Application H17-0811-22
Location Land Off Sunnydale Close Surfleet Spalding PE11 4BS
Proposal Details of archaeological investigation, flood risk assessment and drainage strategy measures, proposed boundary treatments, publicly accessible open space, protected species report, open space management plan, storage and disposal of refuse and recycling, protection of trees, protection of existing hedge, swift nest bricks/boxes, external materials, Sunnydale Close access, gas and electricity external boxes, construction management, estate road phasing and completion plan, surface water disposal and design & location of road/footpath lighting. (Conditions 3, 4, 6, 7, 8, 9, 10, 11, 12, 13, 14, 15, 16, 17, 18, 19, 20, 21 and 22 of H17-1187-21)

Name Diane Gordon
Address Environmental Protection South Holland District Council

Date Submitted 16-01-23
For/Against Comments

DRAWING No: 118-CMP-01

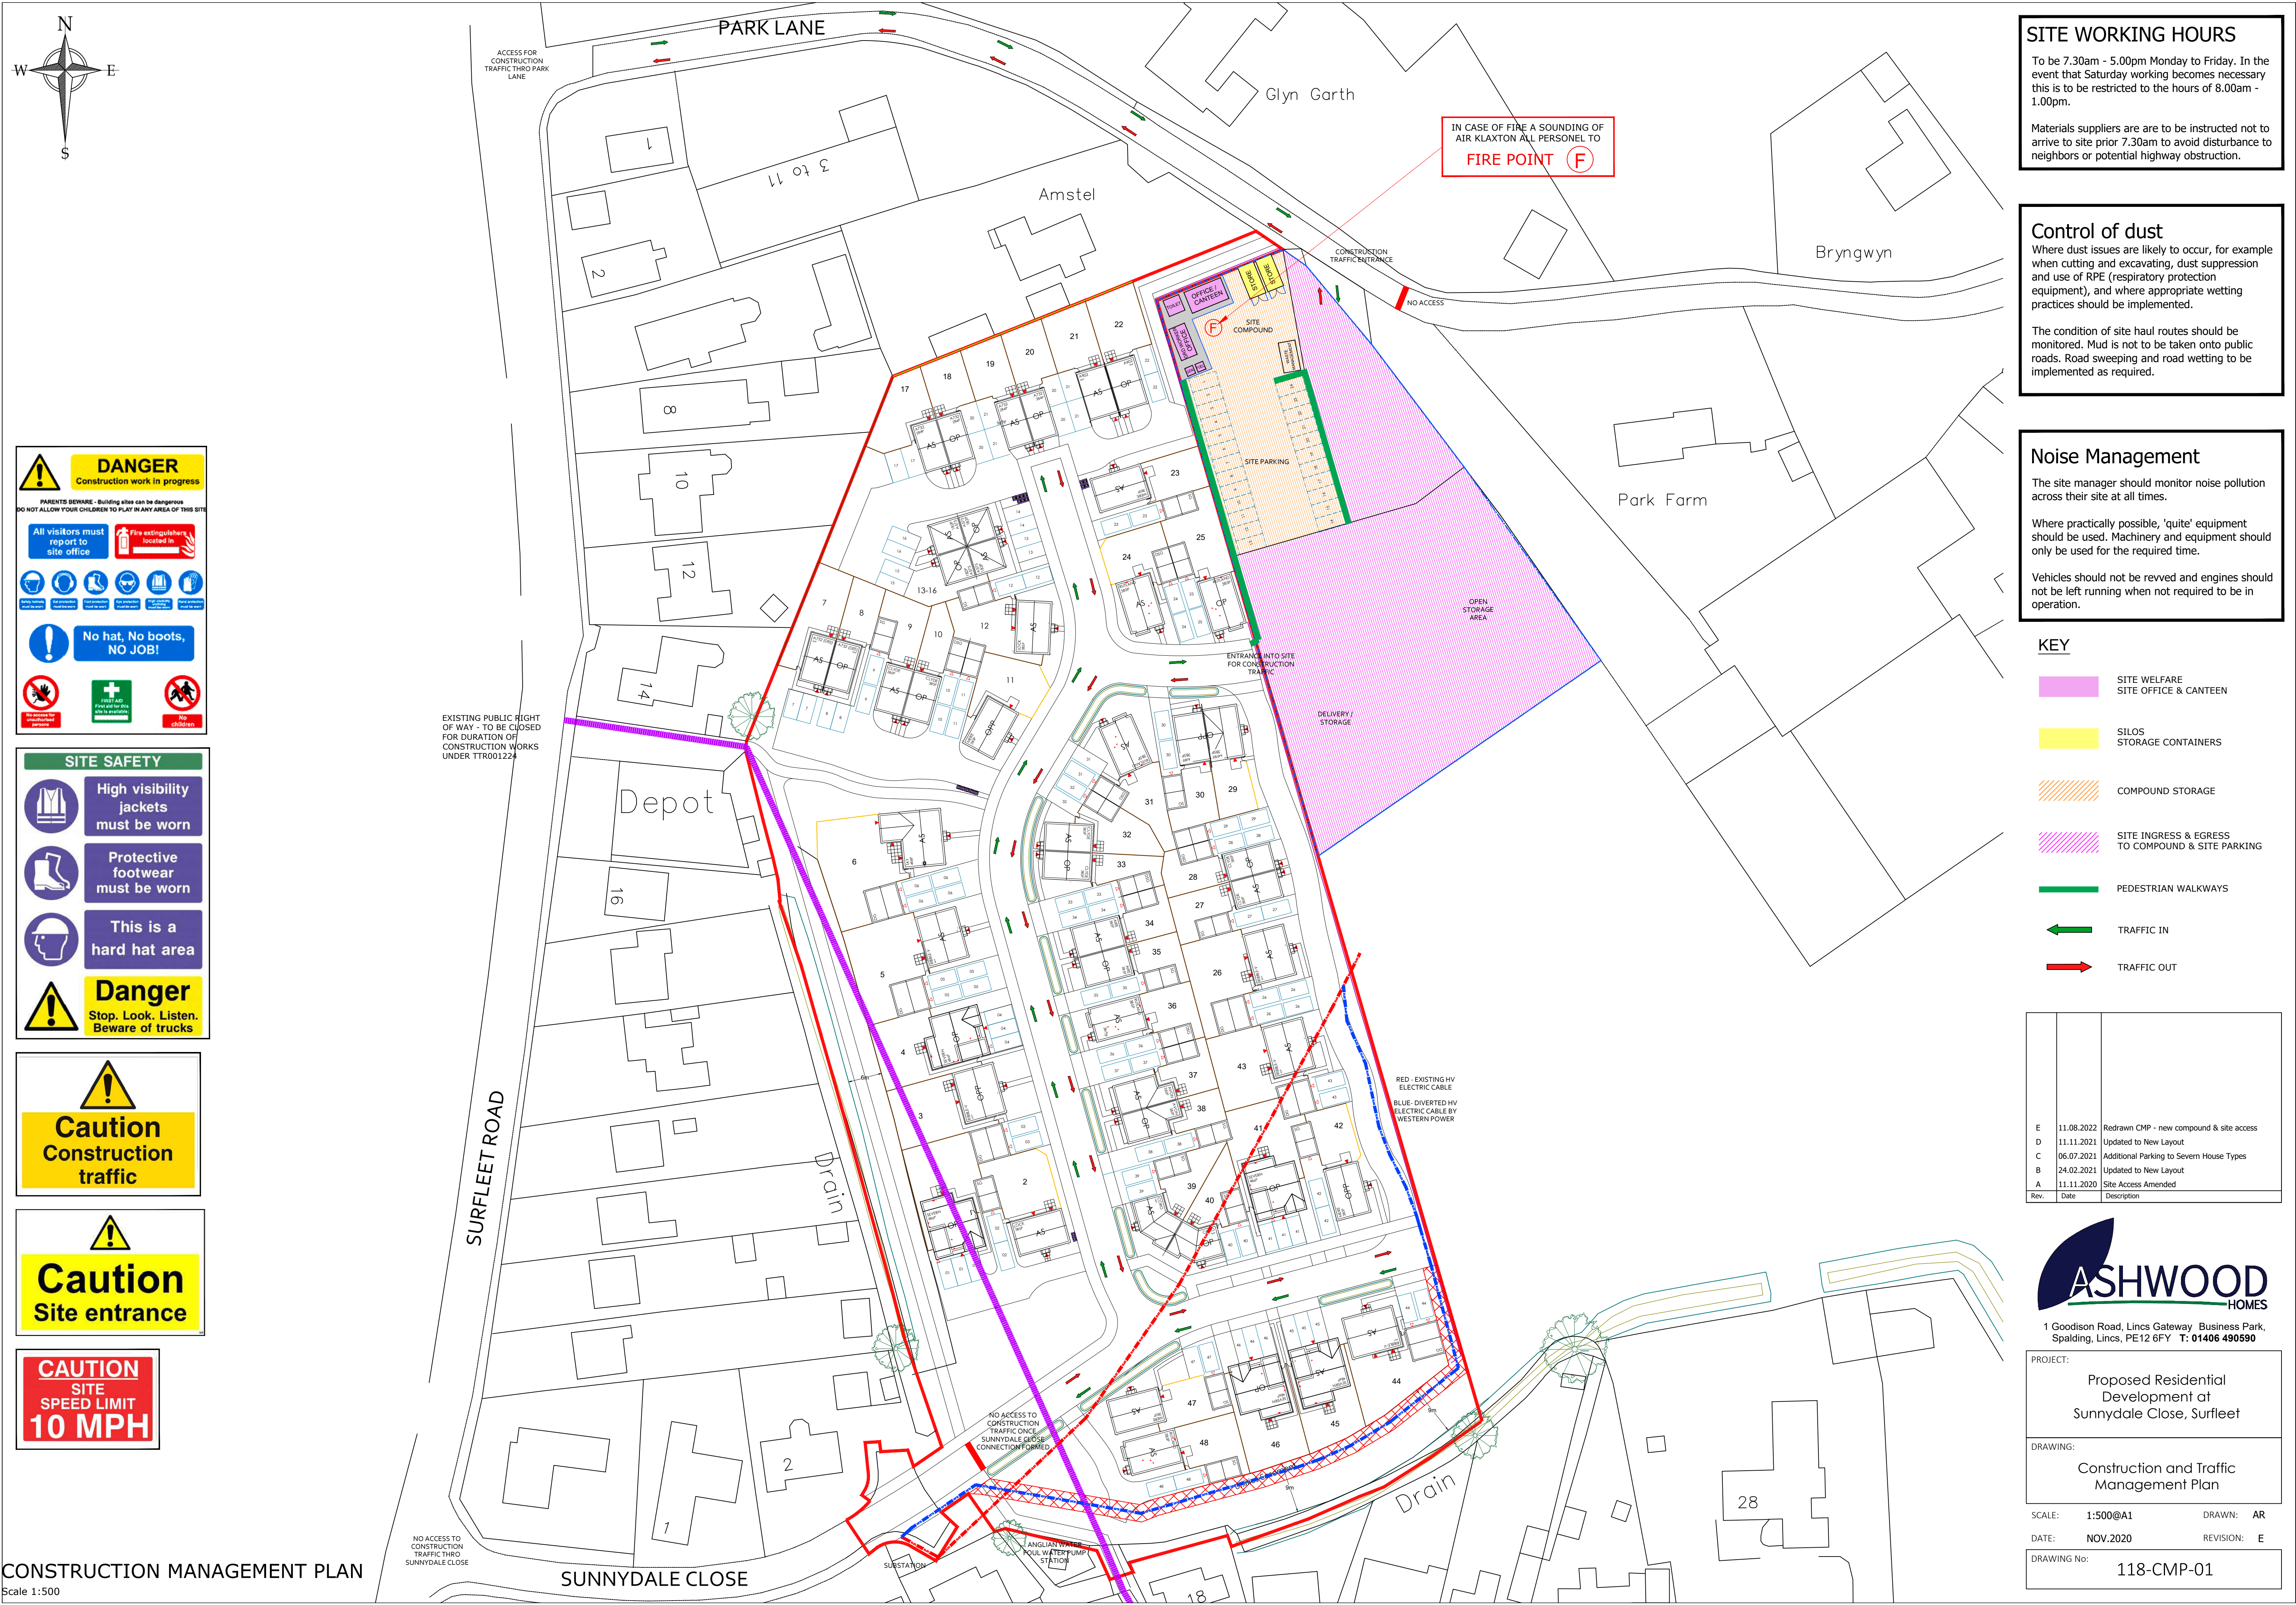
working times should not exceed 7.30-18:00, with no working beyond 13:00 on Saturday, no Sunday working
all vehicle noise and equipment should be kept to minimum to protect amenity of nearby residents.
suitable measures should be in place to manage dust levels during periods of dry weather
no burning permitted on site
